# Markup Summary

GRADING AND EROSION CONTROL PLAN

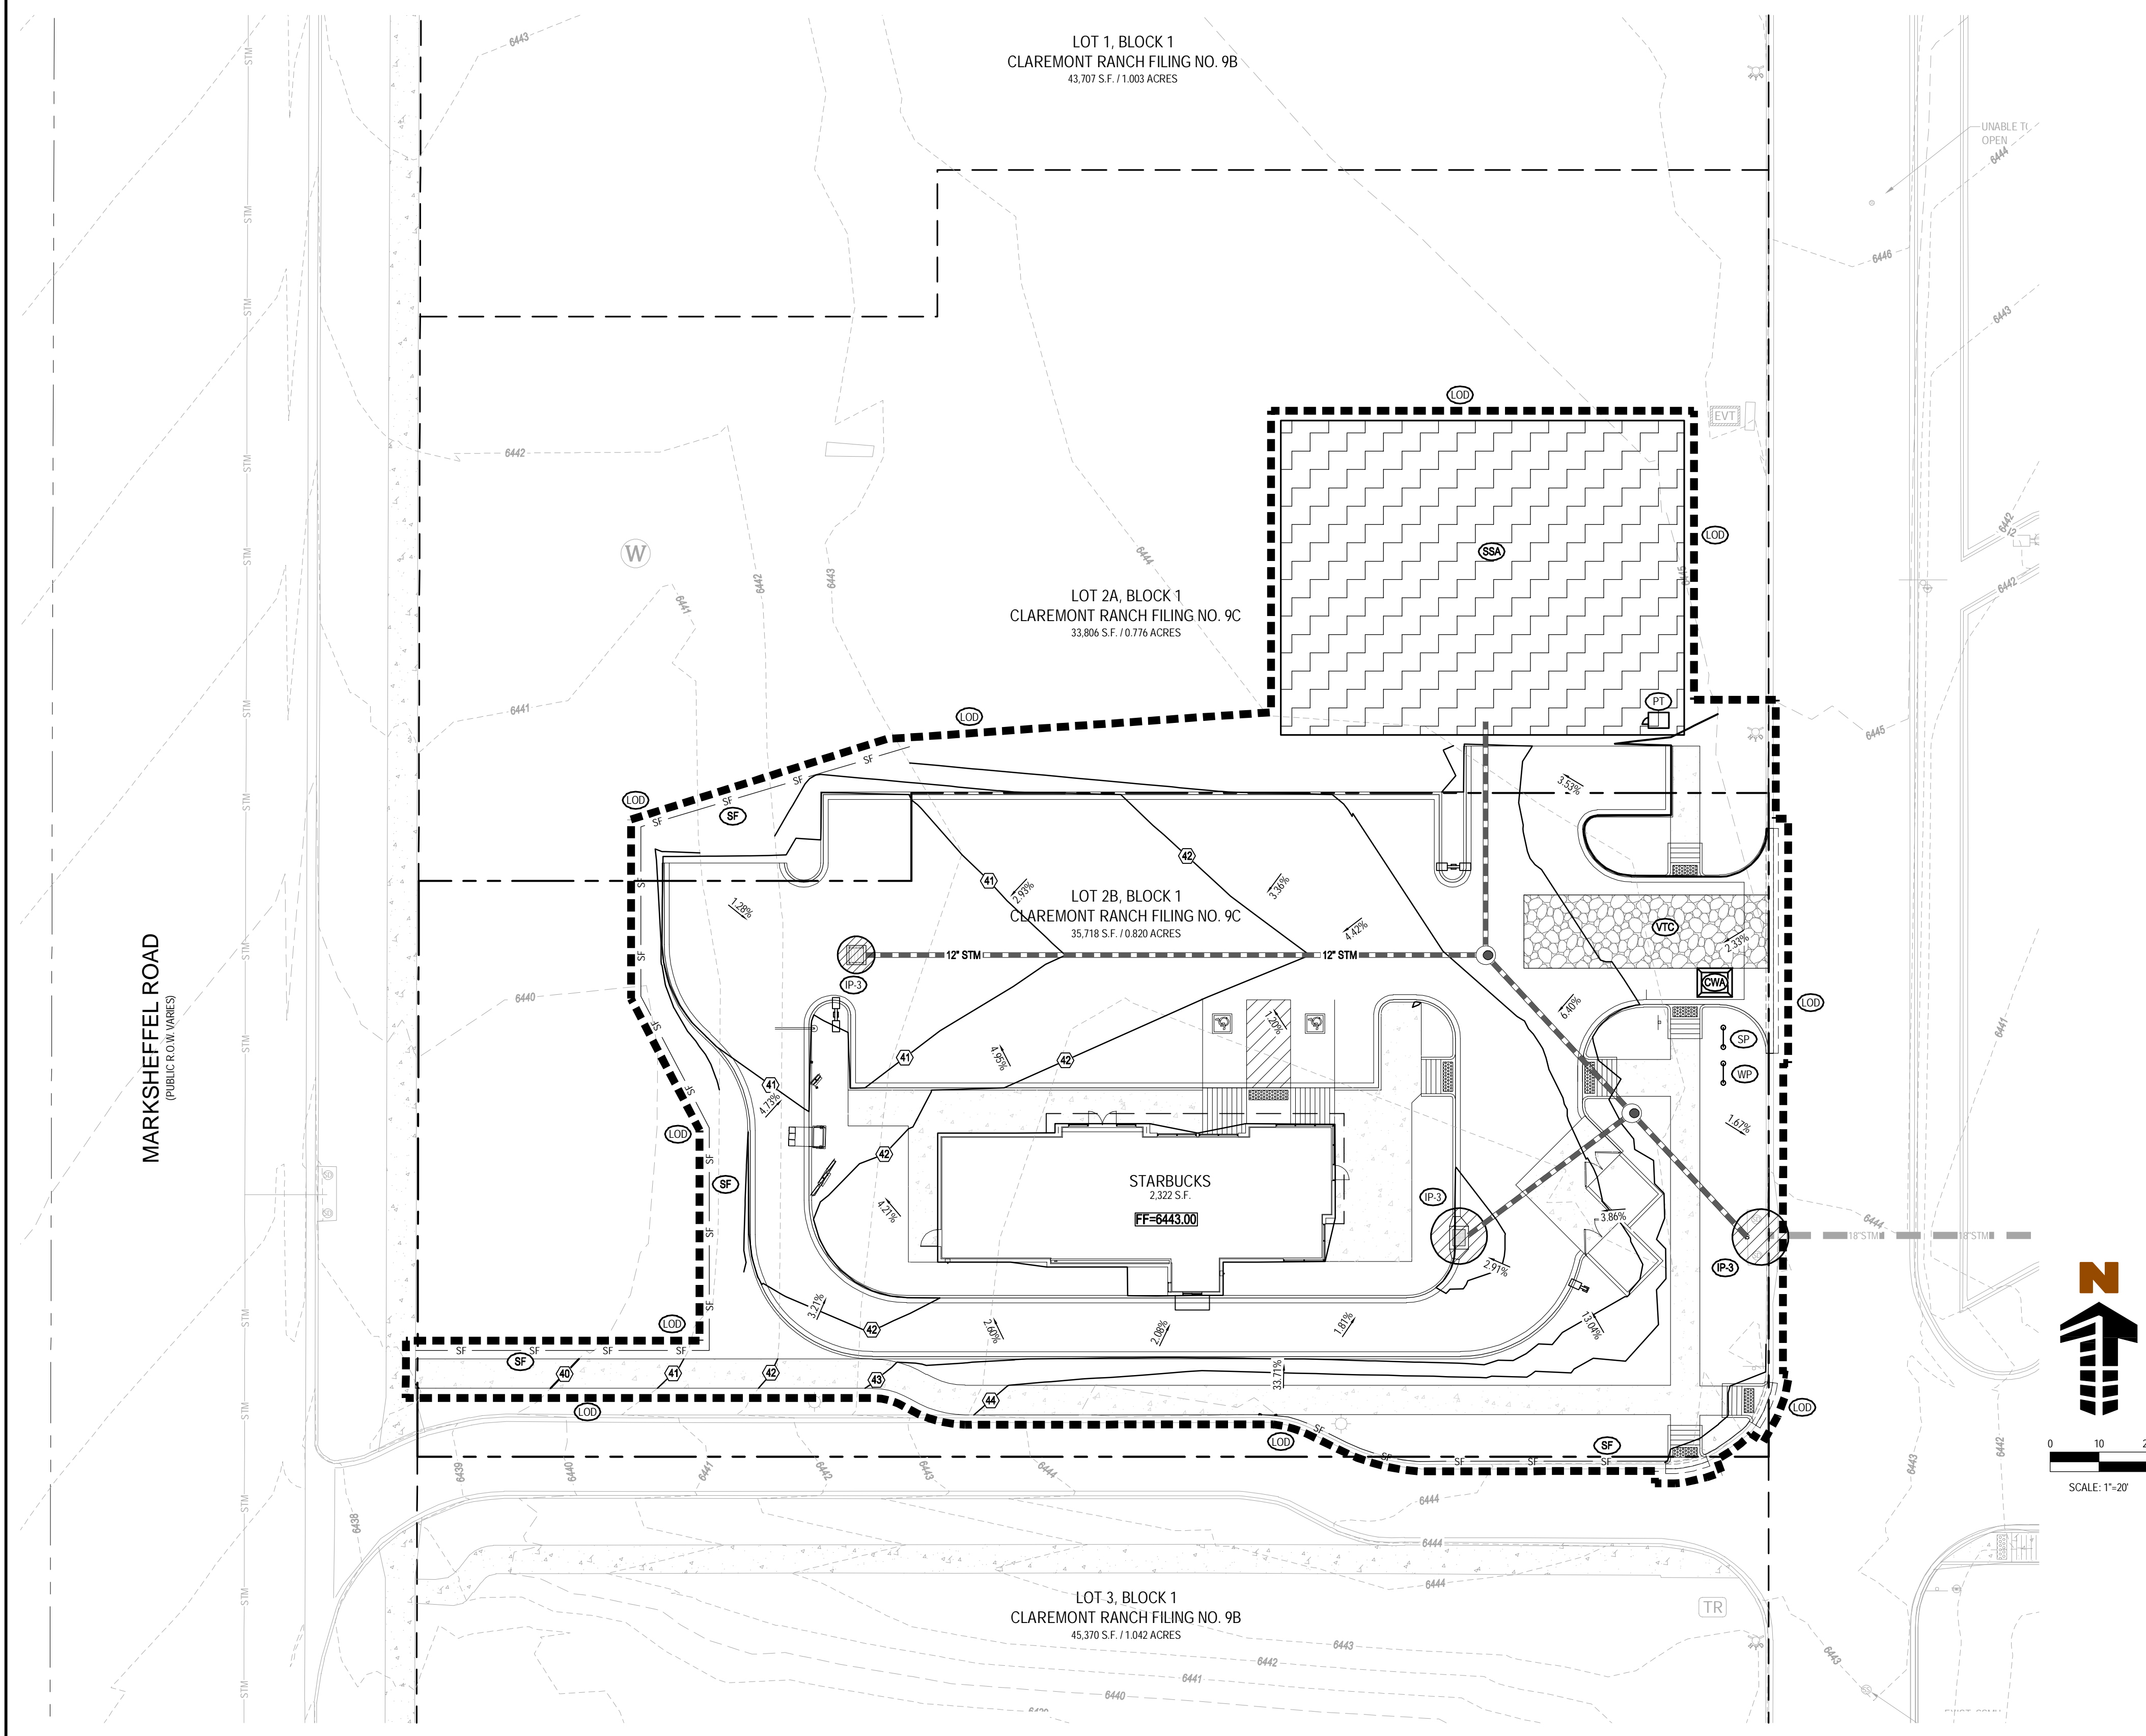
Include the details for the temporary BMPs

Add a coversheet with  
vicinity map  
sheet index  
point of contacts

Fill in the blank

Change the title to "Grading and Erosion Control Plan"
